City of Portland, Maine - Building or Use Permit Application
 389 Congress Street, 04101 Tel: (207) 874-8703, Fax: (207) 874-8716

Permit No: 04-0399	Issue Date:	CBL: 224 A025001
------------------------------	--------------------	----------------------------

Past Use: Vacant	Proposed Use: PRUD 12 unit condominium / Building # 4 (3 units).	Permit Fee: \$2,946.00	Cost of Work: \$300,000.00	CEO District: 3
Proposed Project Description: PRUD 12 unit condominium / Building #4 (13 units).		FIRE DEPT: <input type="checkbox"/> Approved <input type="checkbox"/> Denied	INSPECTION: Use Group: Type	
		Signature:	Signature:	
PEDESTRIAN ACTIVITIES DISTRICT (P.A.D.)				
Action: <input type="checkbox"/> Approved <input type="checkbox"/> Approved w/Condition <input type="checkbox"/> Denied				
Signature:		Date:

Dept: Zoning	Status: Approved with Conditions	Reviewer: Marge Schmuckal	Approval Date: 04/23/2004
Note: the entire site is 12 condo dwelling units - this bldg #4 is 3 condo dwelling units			Ok to Issue: <input checked="" type="checkbox"/>

# STAIR DETAIL

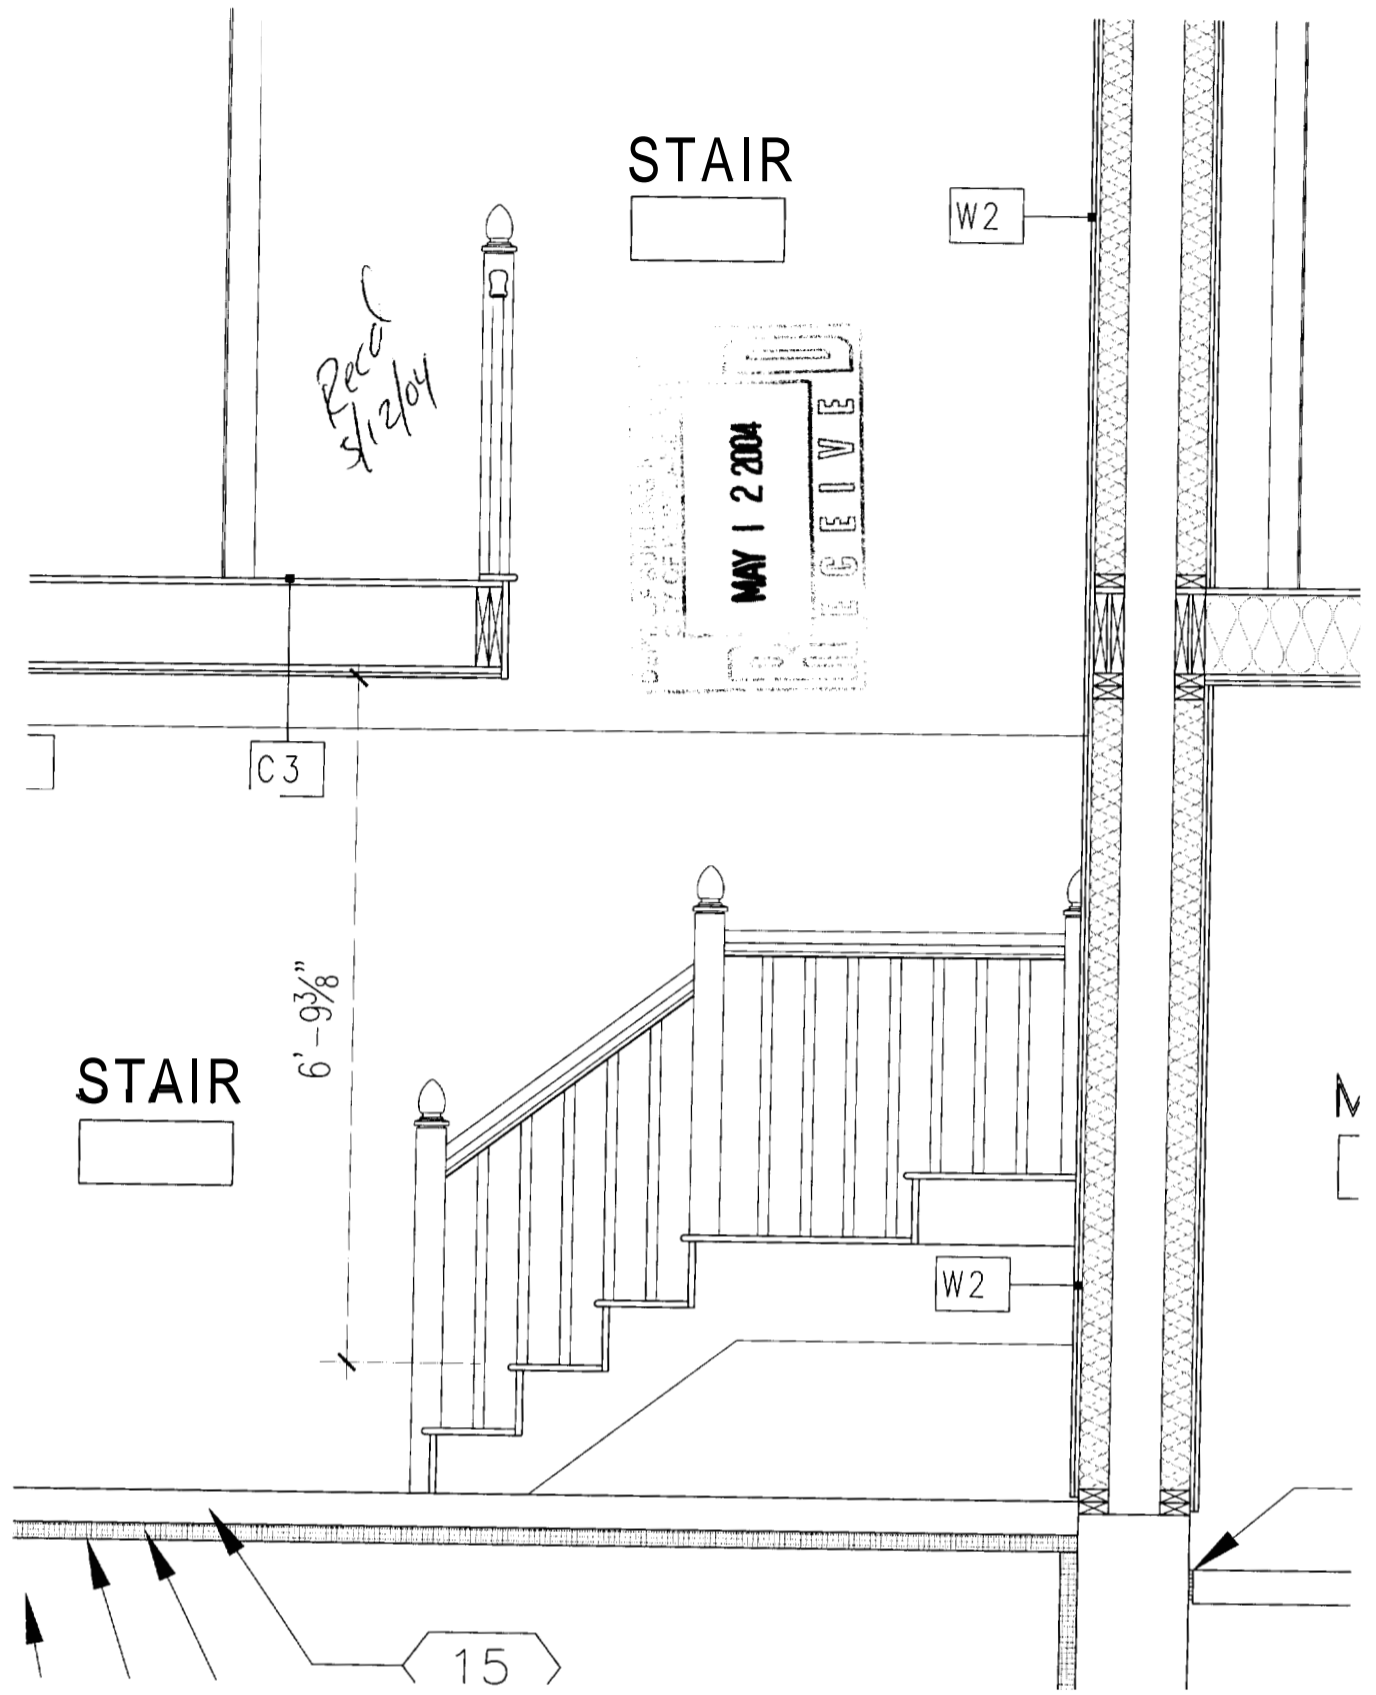
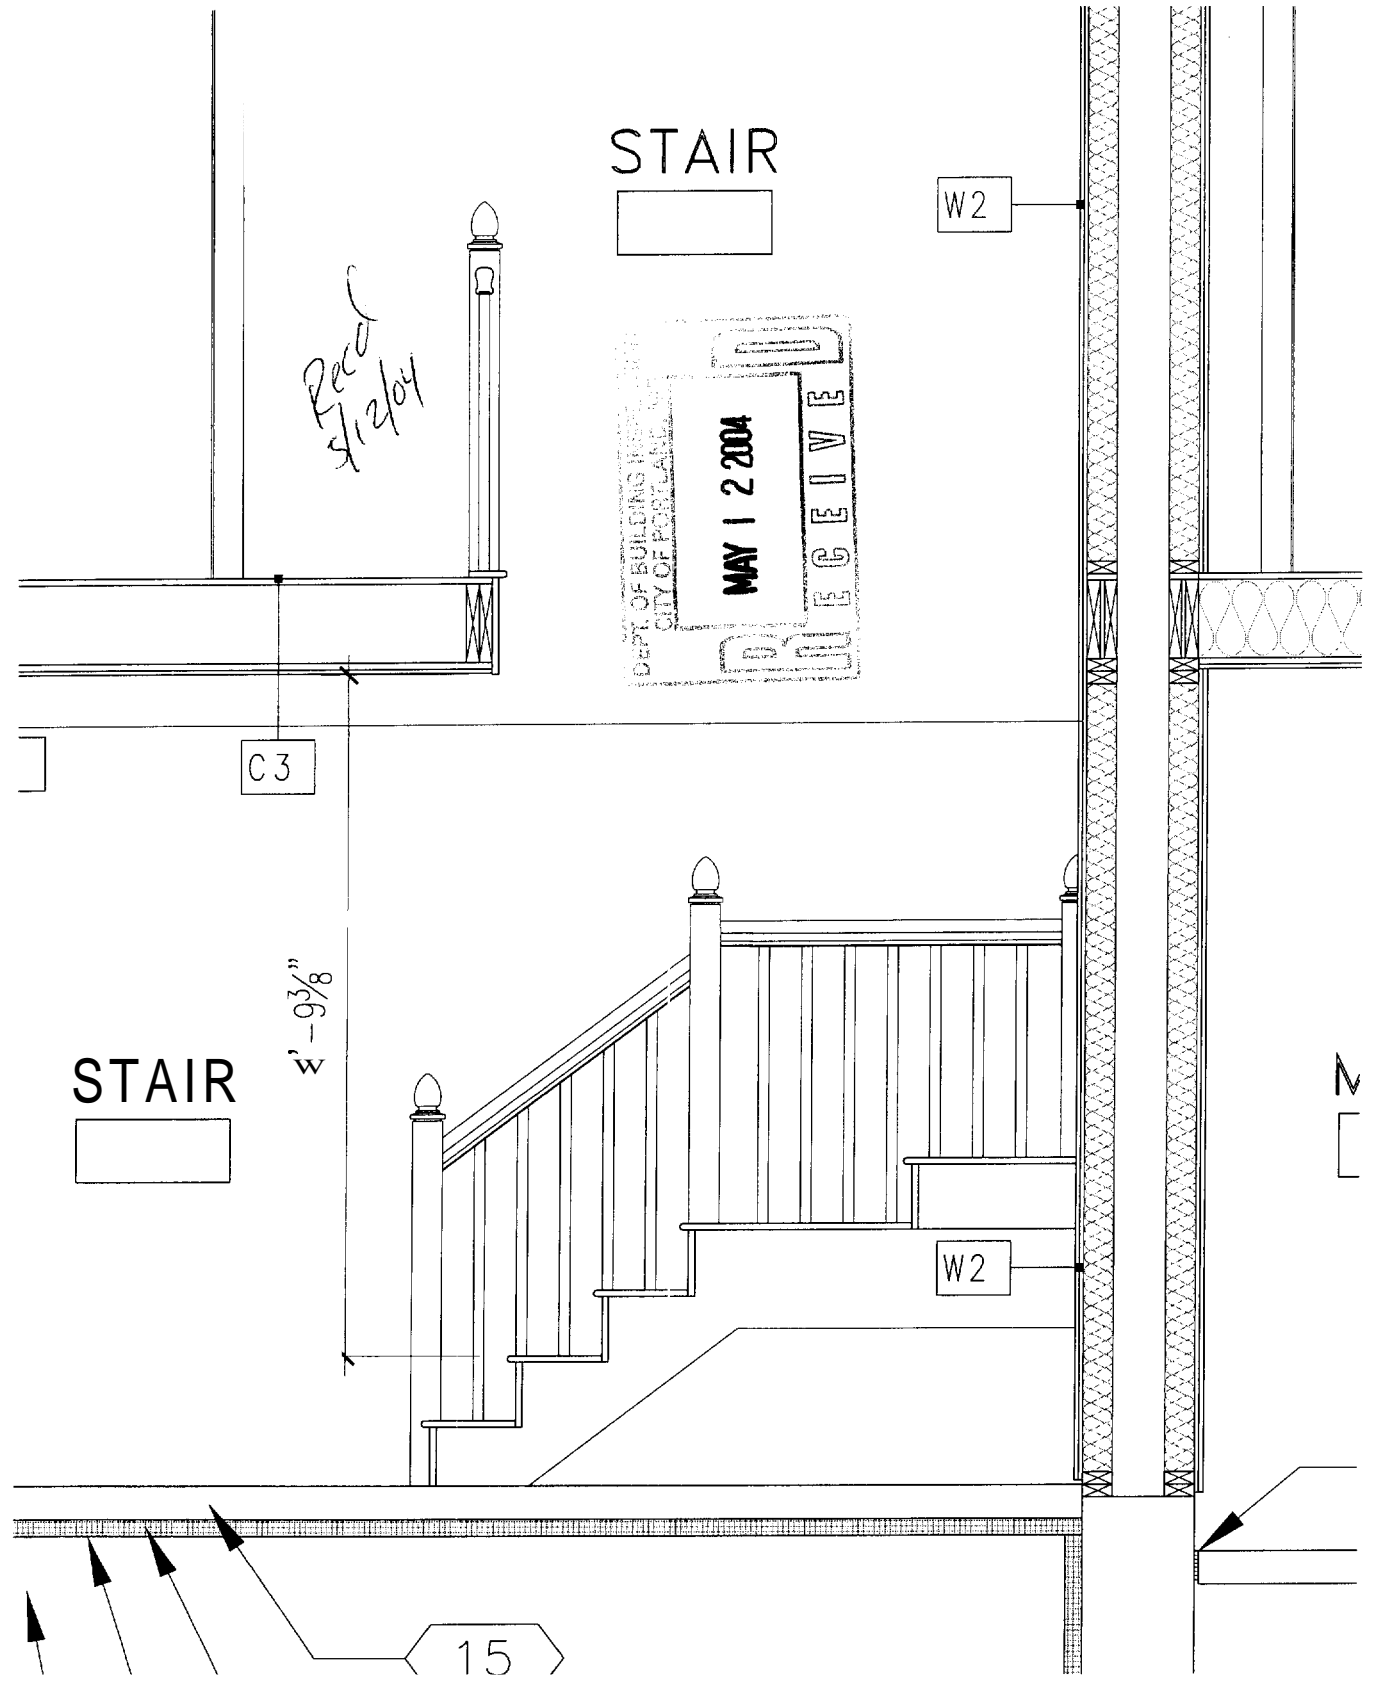
Comments:
4/30/04-tmm: need stair details, attic acces info, third floor weight calc's for hvac equipment, smoke det locations, clearance in chase, fire blocking in tenant separating walls and structural support of walls, - faxed info to builder.
5/12/04-tmm: rec'd above info - okto issue
